Re: Gonzales Residence

6308 Petirrojo NW

Request Permanent C.O. - Accepted

Engineer's Stamp dated: 12-23-15 (D10D003F11)

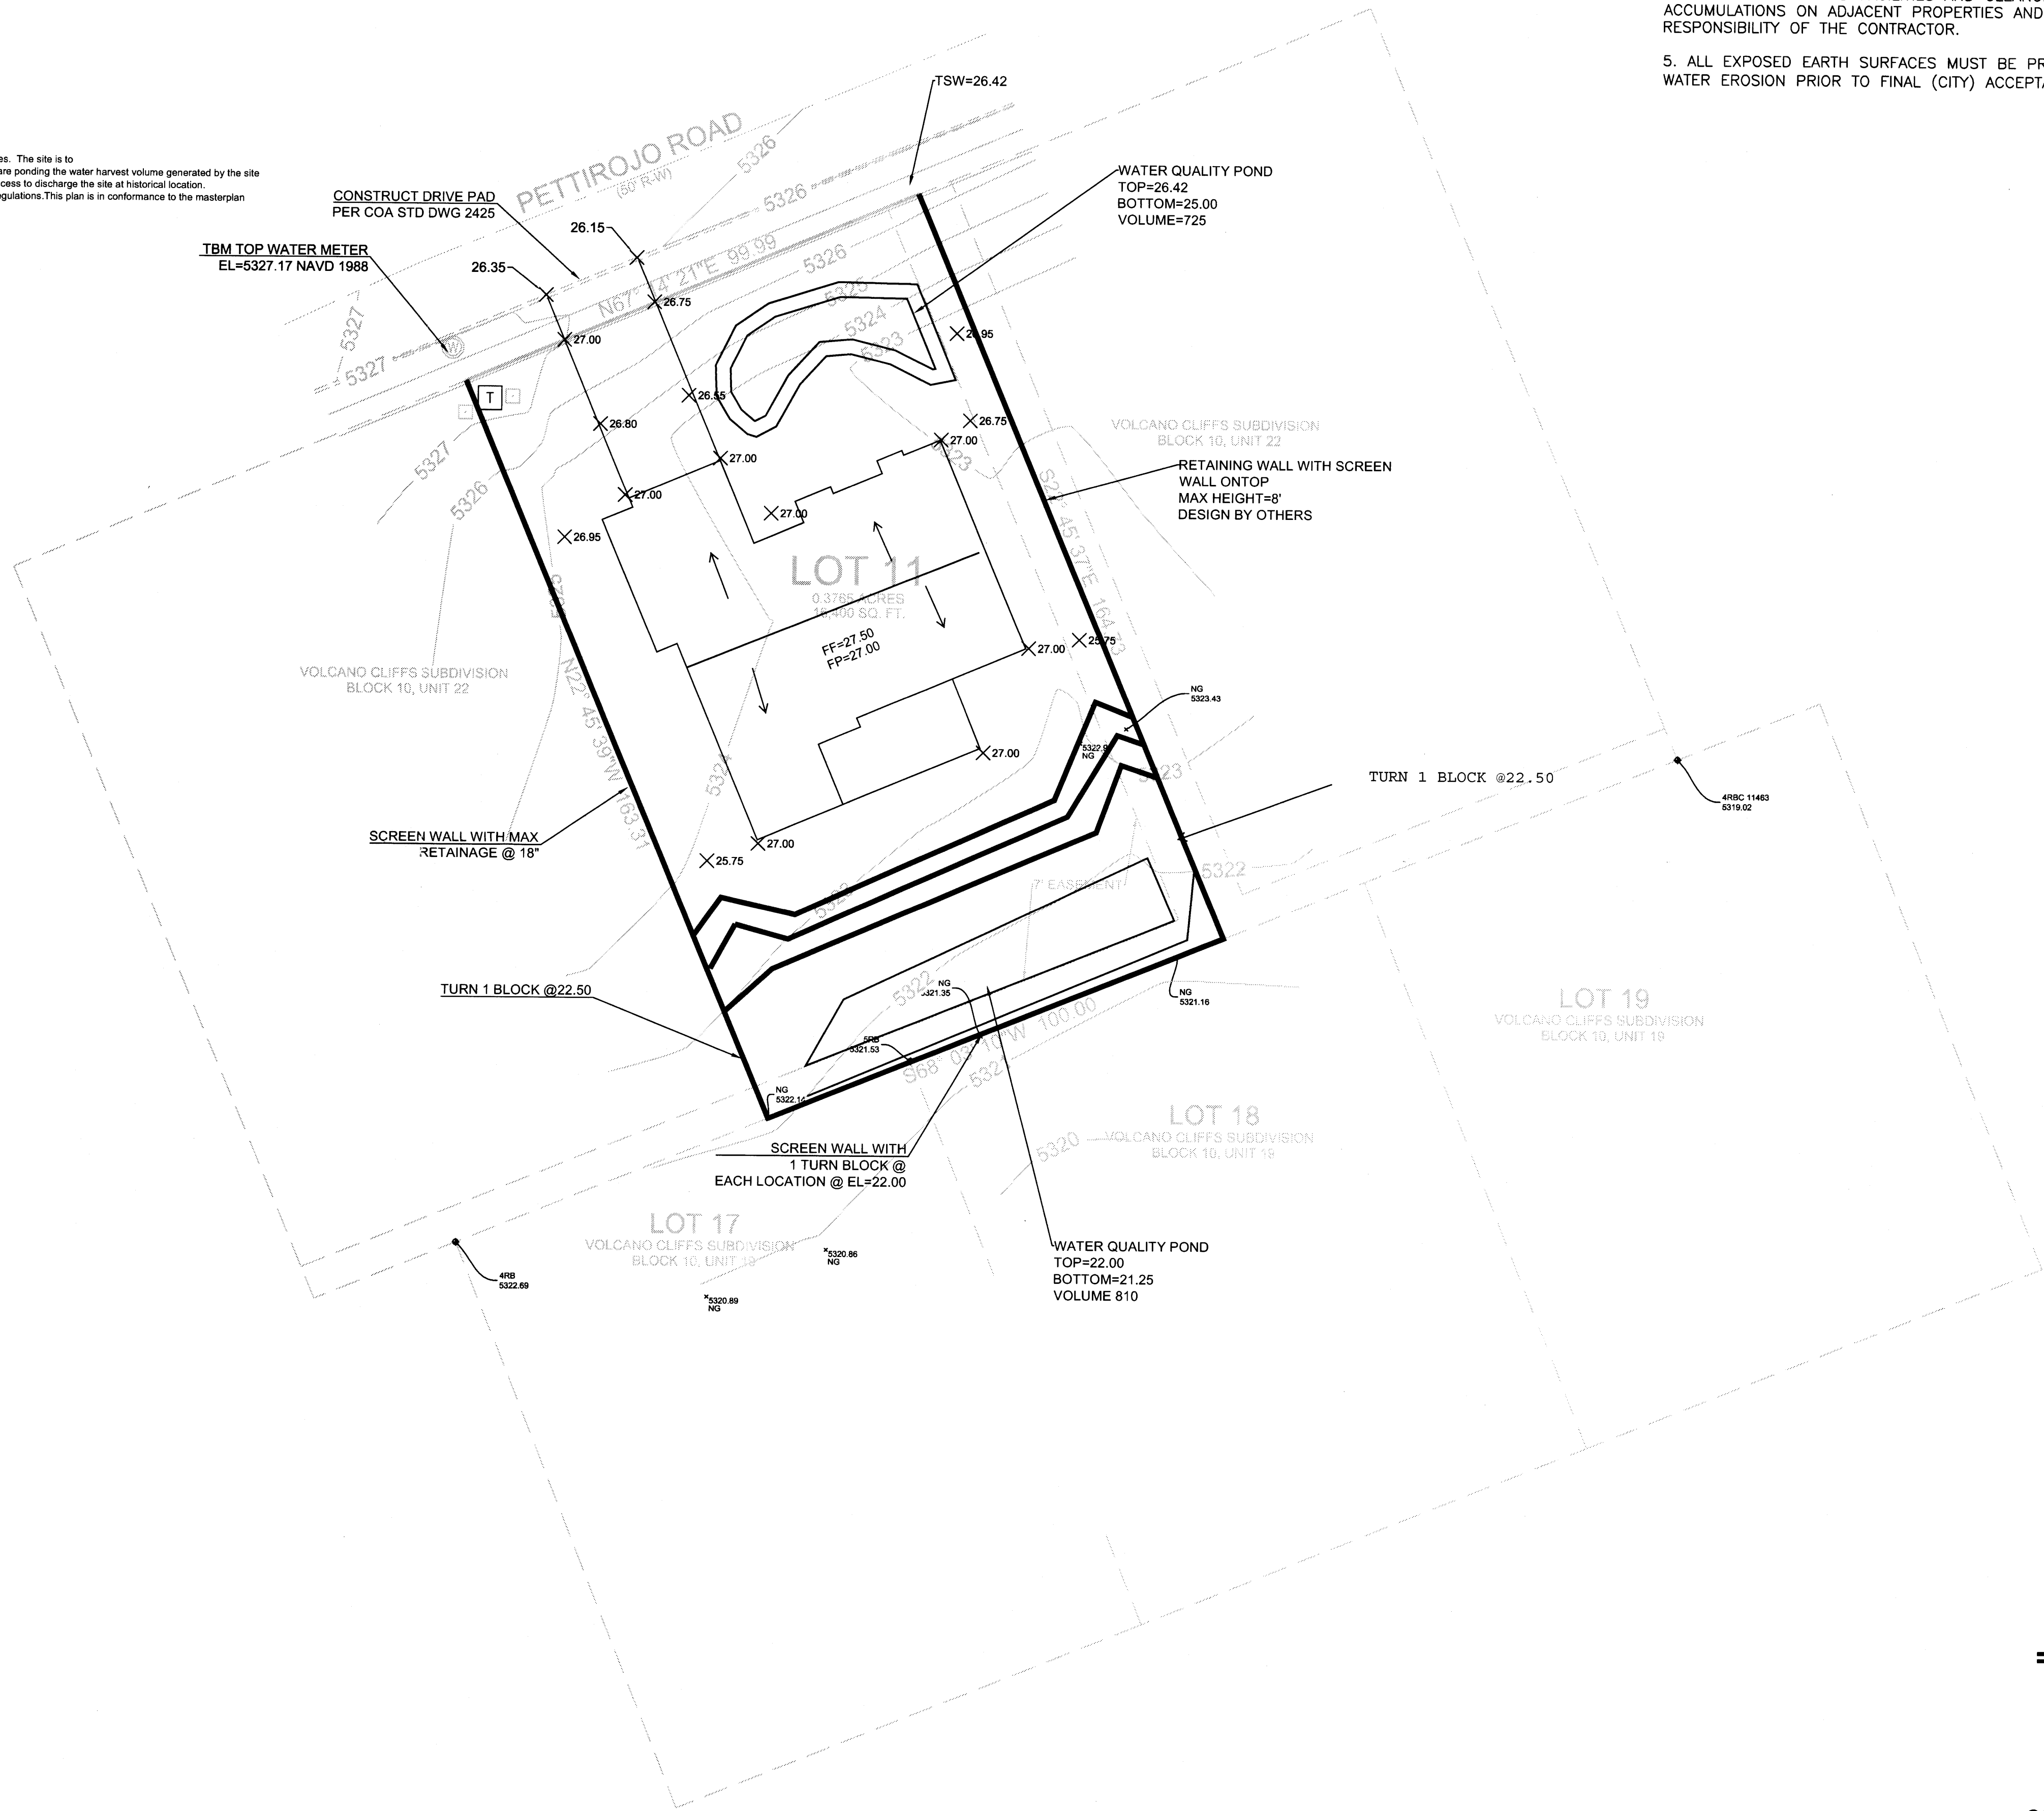
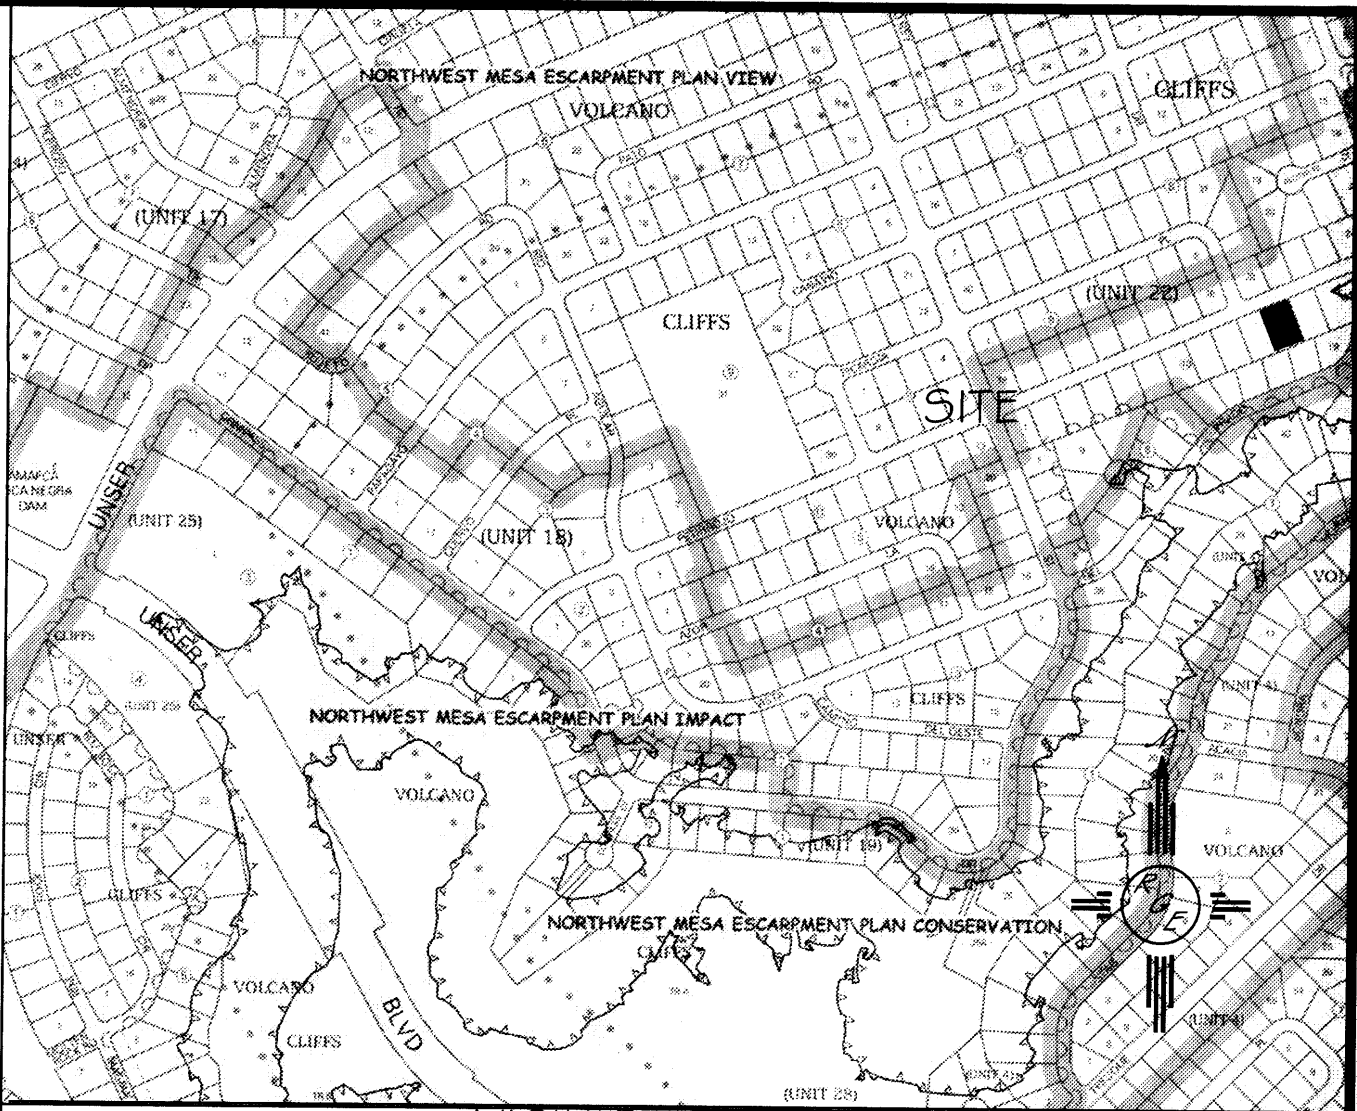
- This lot drains to two different ponds, the front half flows to pond 8 and the back half flows to pond 9, provide a site plan depicting this requirement.
- The turn blocks are located in the wrong fence line, the turn blocks should be placed in the east and west rear yard walls.

- 1. This lot drains into two basins, the front to pond 8 and the back to pond 9, revise site We previously had incorrectly located the lot on the wrong block in our analysis. We have revised the plan to conform to the basin map fro SAD 228. We have enclosed this map and identified the lot on the map.

- 2. The turn blocks are located on wrong fence line, turned blocks should be on east and west in order to have the site conform to the proposed condition basin map, the pad needs to be elevated. This causes retaining on the east and west property lines. We have added turned block on these walls at the south portion of the lot, where the flow can be accepted and passed. Based upon the existing contours and the location of Pond 9, we propose to have the turn blocks on the south wall remain. This design better matches existing and proposed flow conditions shown in the SAD 228 drainage plan.
